Planning Application No: 3/2025/0506

Proposal: Proposed demolitions, single storey rear extension and alterations.

Location: 37 Waddow Grove Waddington BB7 3JL

The plans and highway related information submitted have been viewed and the following comments are made.

1 PROPOSED GROUND FLOOR PLAN  
1 : 50

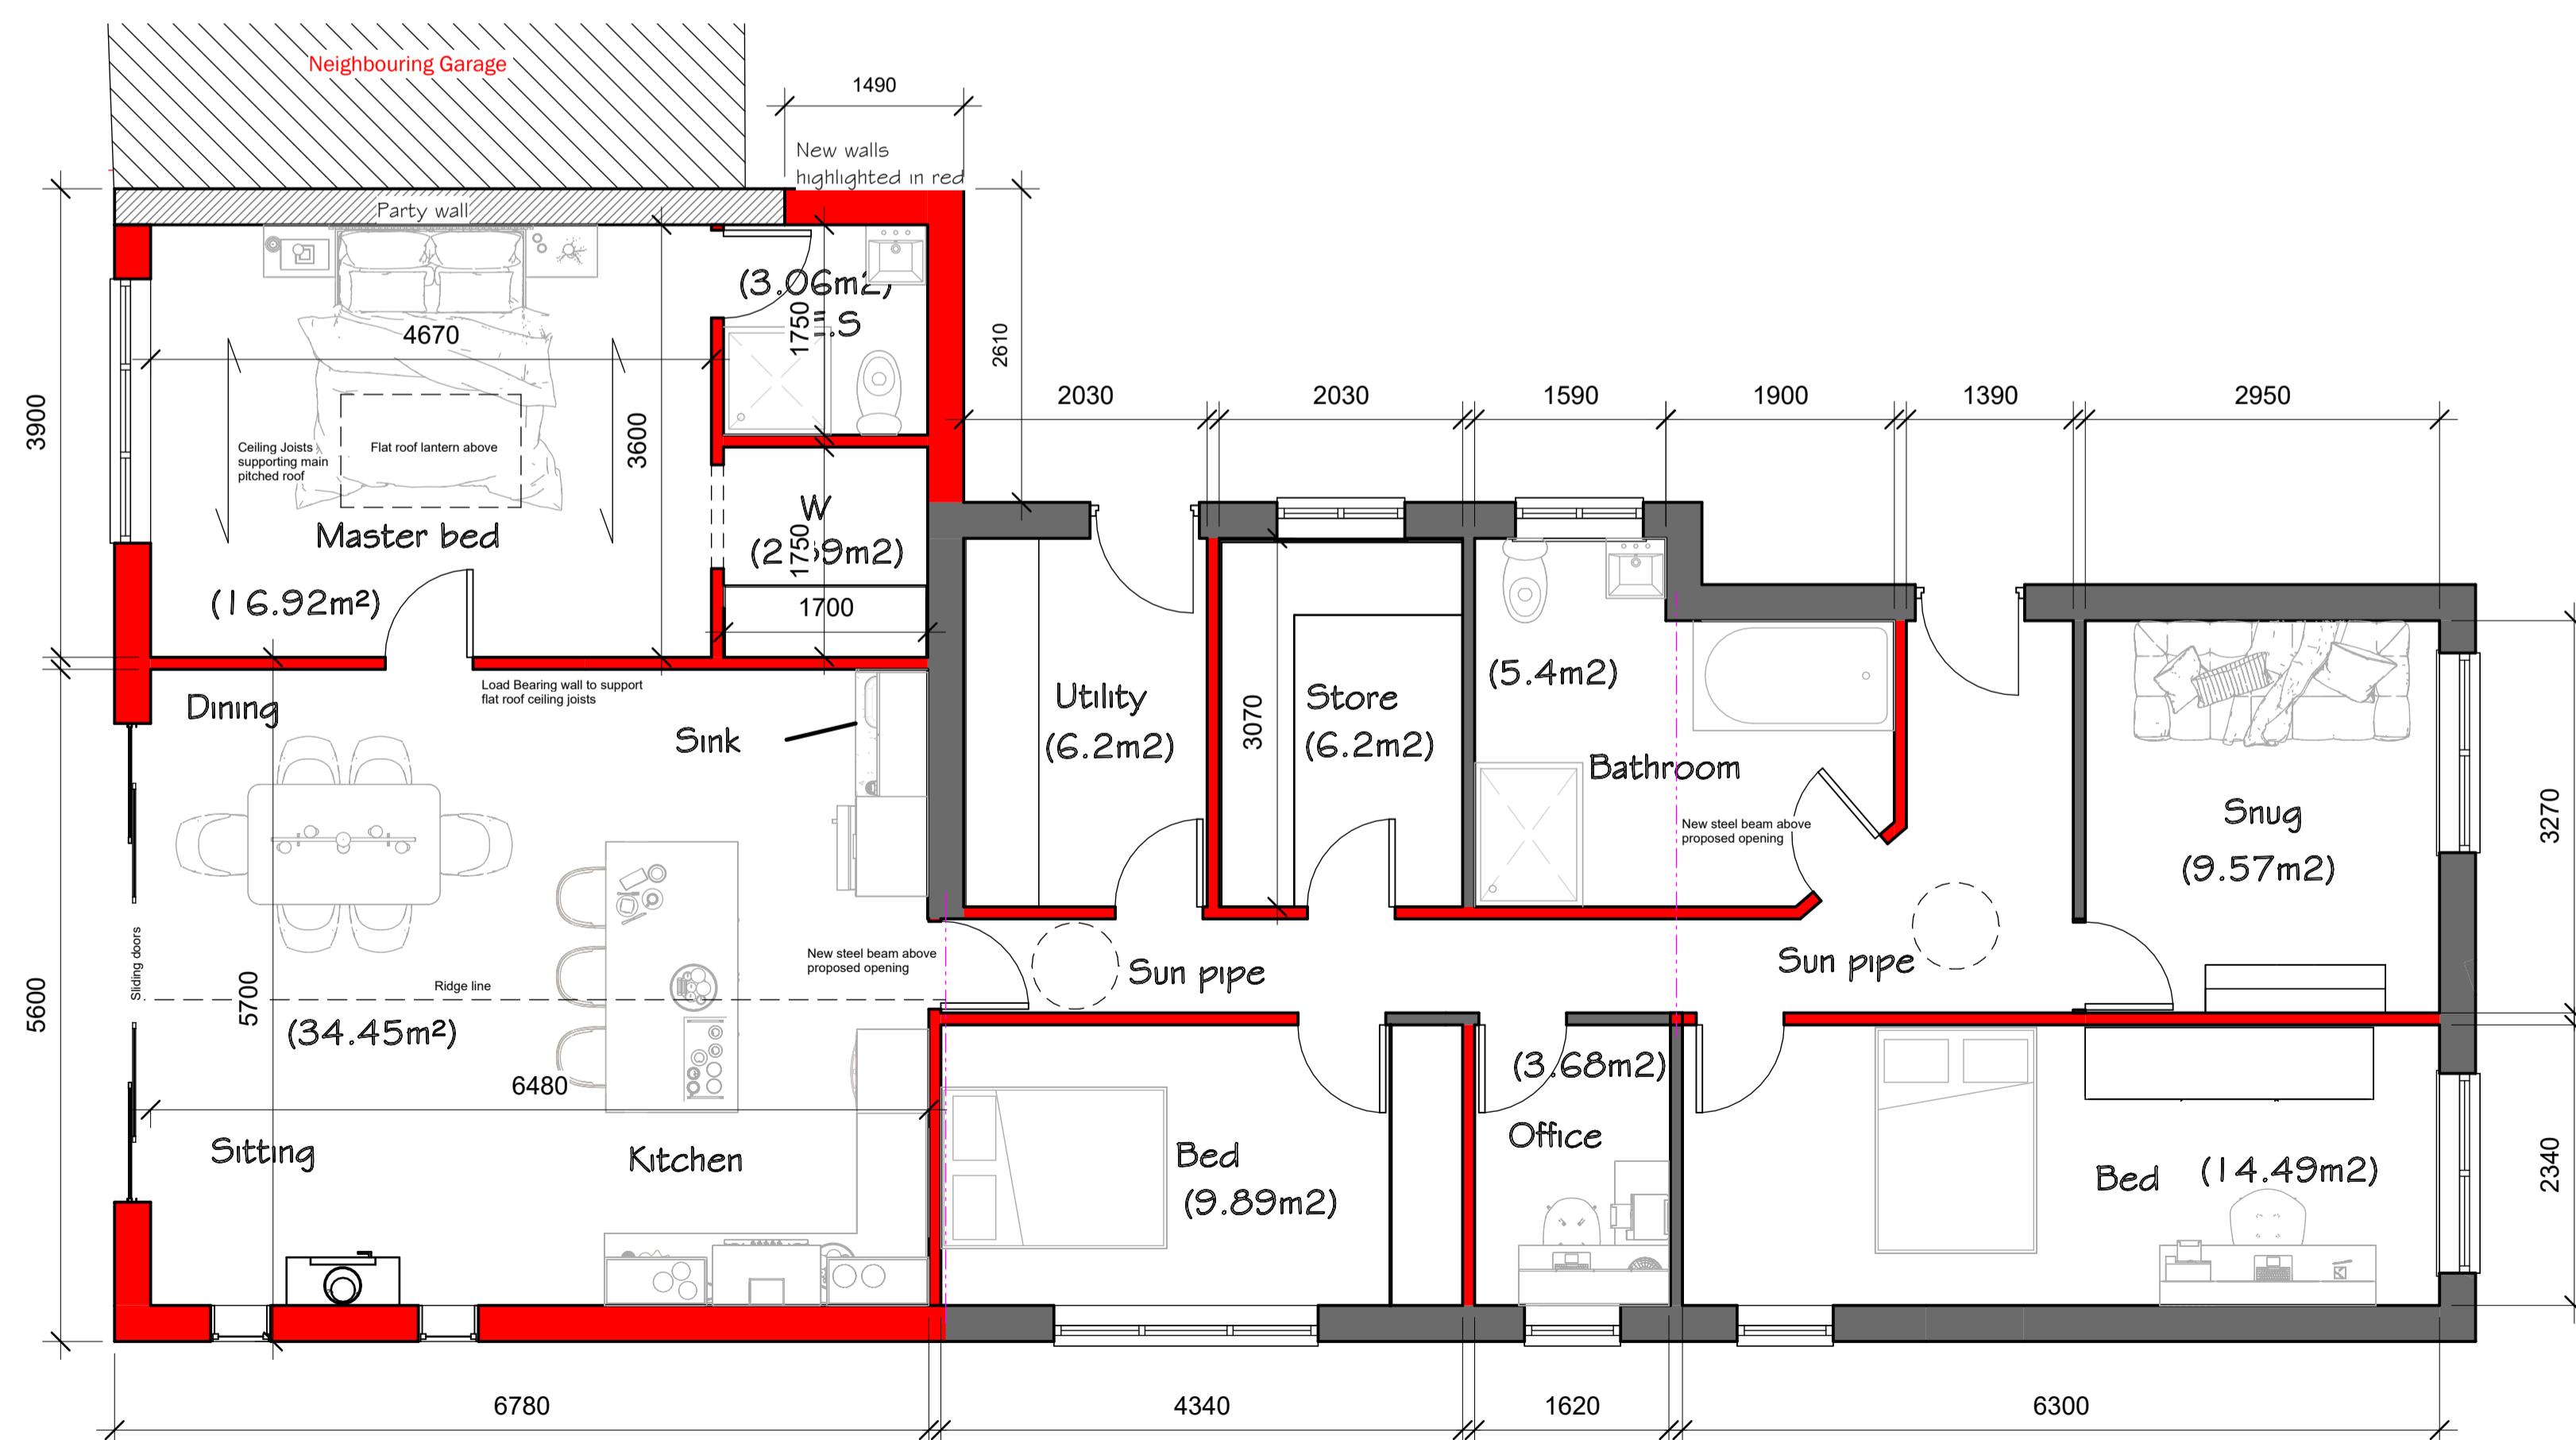
With ref. Design Statement there is no change in number of bedrooms. Three number bedrooms will remain. There is a loss of a garage and a proposal for the new parking to be in the garden area. These can be achieved; however, this requires an extension to the vehicle crossing across the full length of the drive in order to prevent damage to the footway. Also, for the parking spaces to be usable they need to be side by side, like others have done along the Grove.

- The parking areas must be constructed of a bound porous material and created before first occupation up until the lifetime of the dwelling existing in its proposed state. Reason: To ensure that satisfactory parking is provided before the dwelling hereby permitted becomes operative.
